Drafted 26 September 2012

**Outline Planning Application, Ribble Valley District
D3-12-0497 Strawberry Fields, Gisburn**

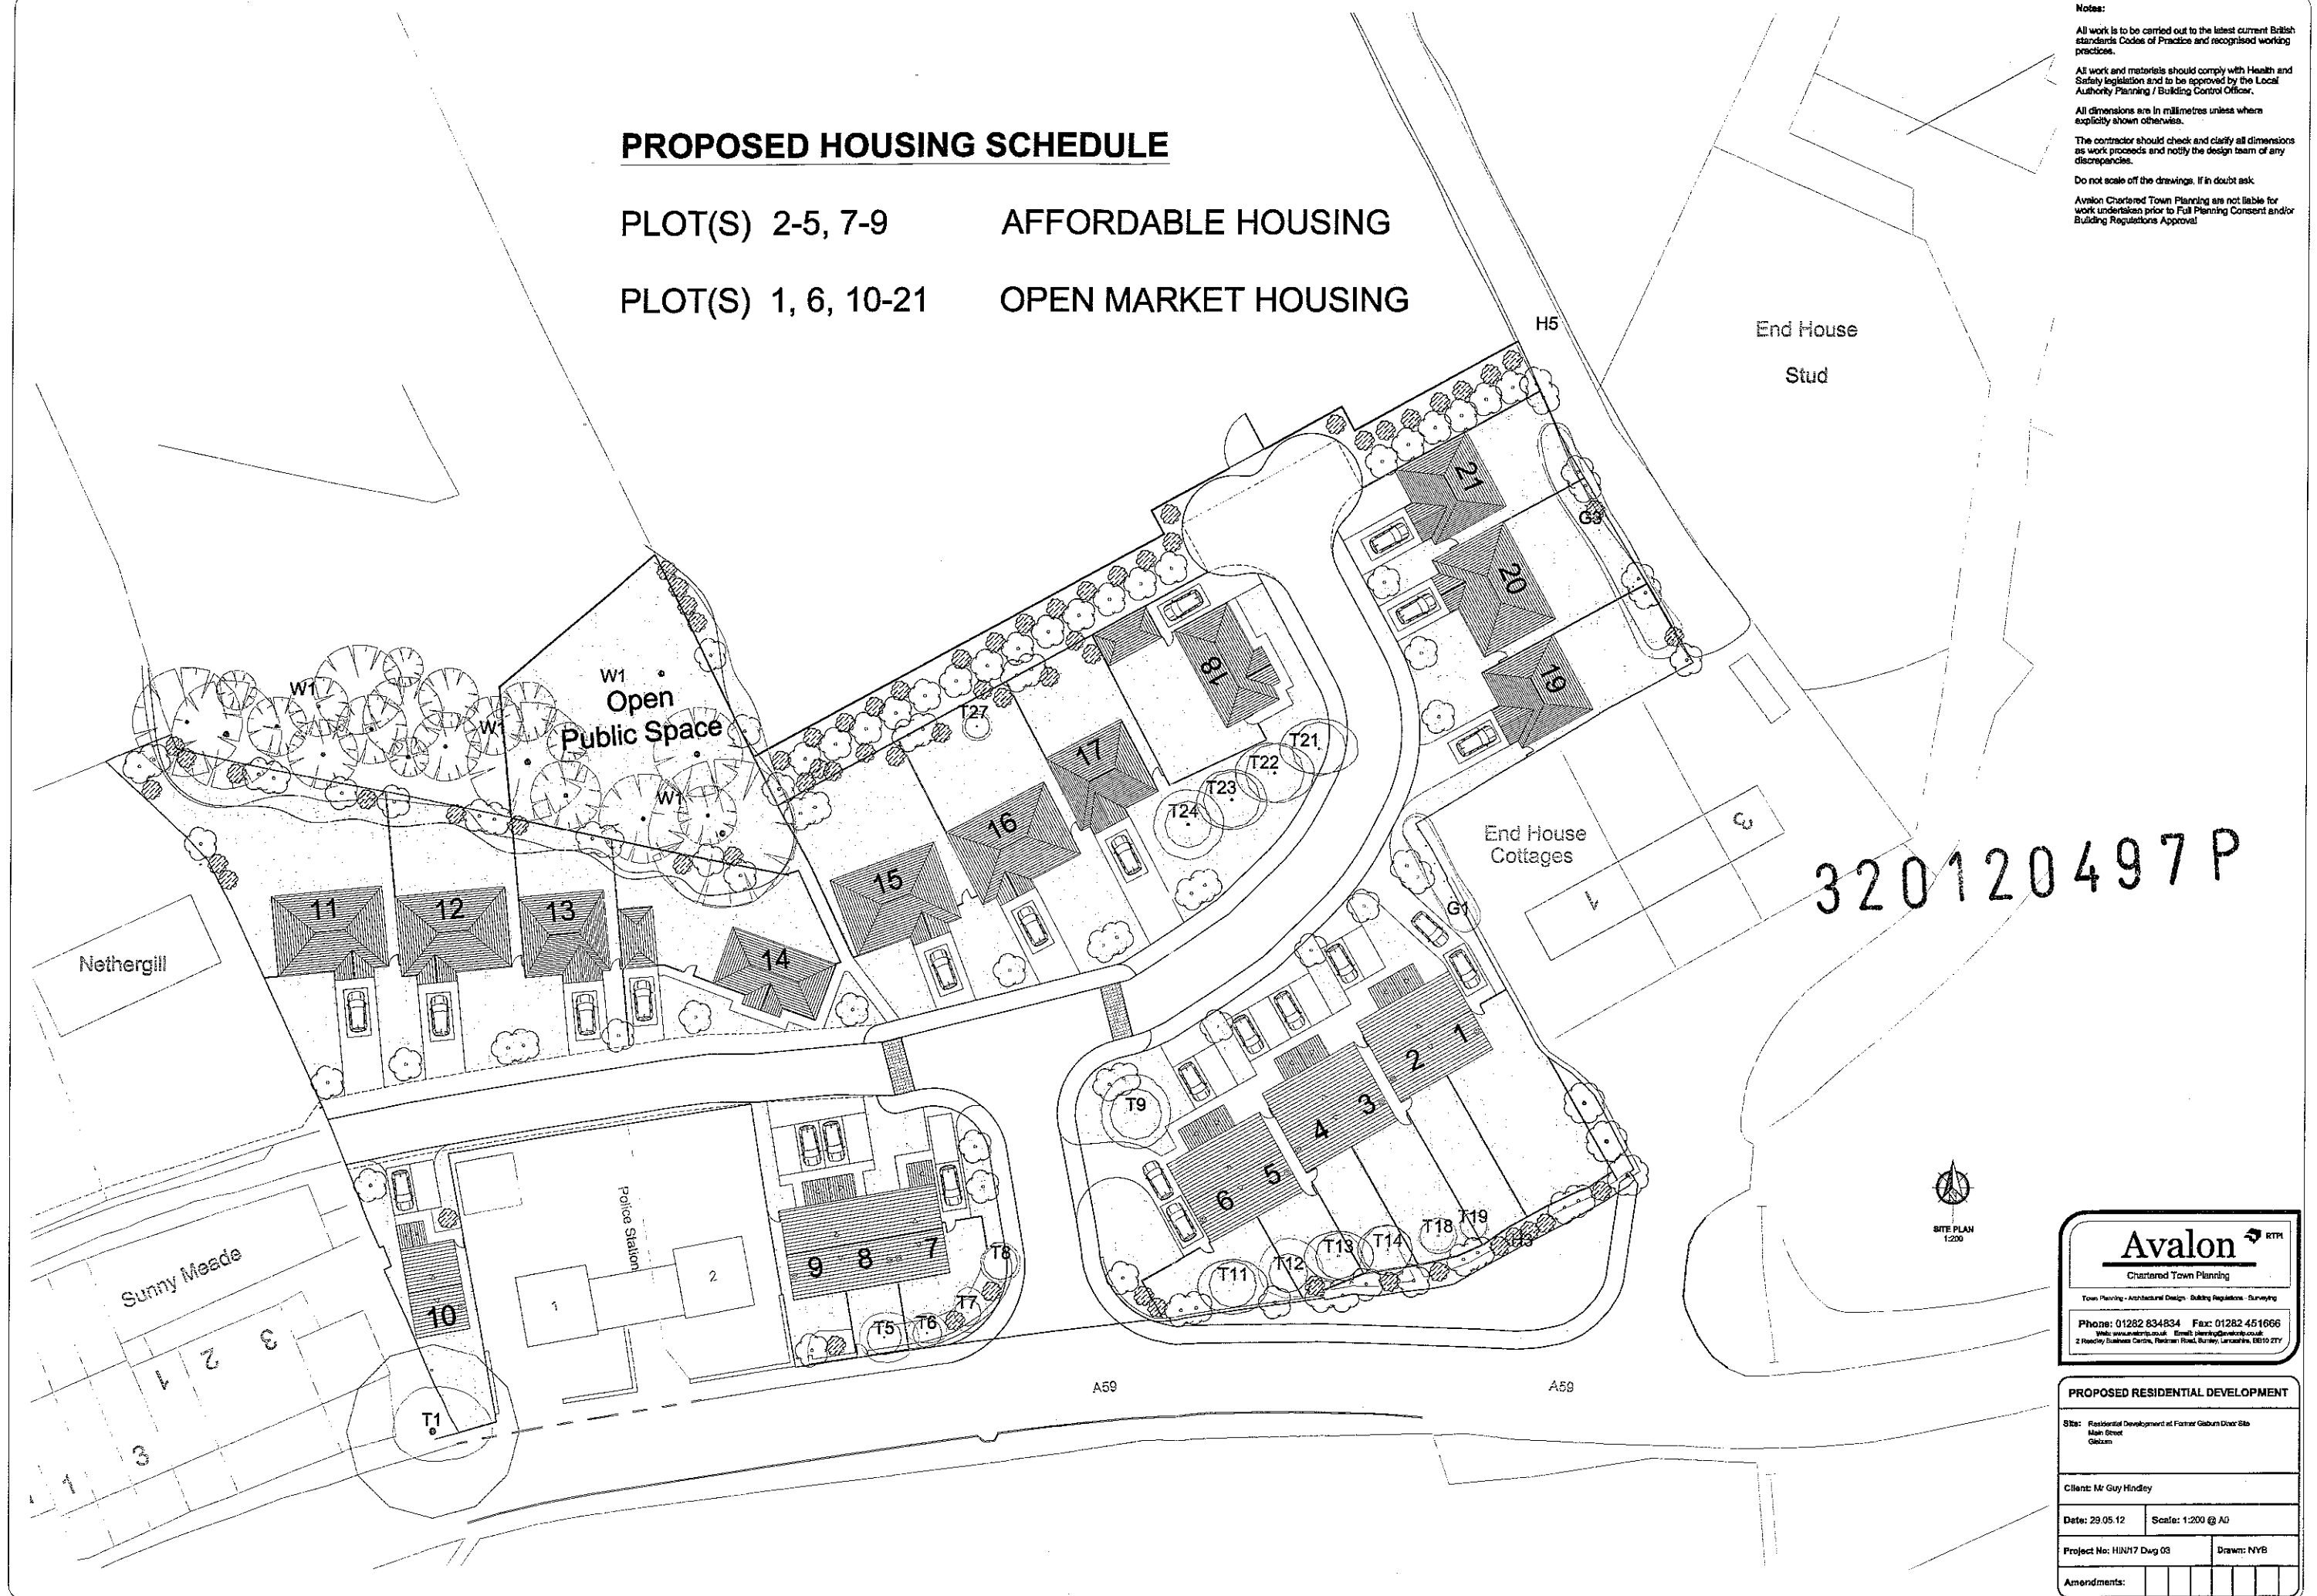
The amended plan, Dwg03: Amendment A, addresses the concerns I expressed in my initial response.

1. The extent of the footway provisions within the site have been clarified and are acceptable.
2. The lack of footway provision on the south side of the access road has been resolved.
3. The proposed extent of any proposed highway adoption will be determined at a later date.
4. Suitable turning facilities have been identified within the site.
5. While still at the outline stage, the distribution of housing types and sizes that have been identified are consistent and secure appropriate parking provisions.
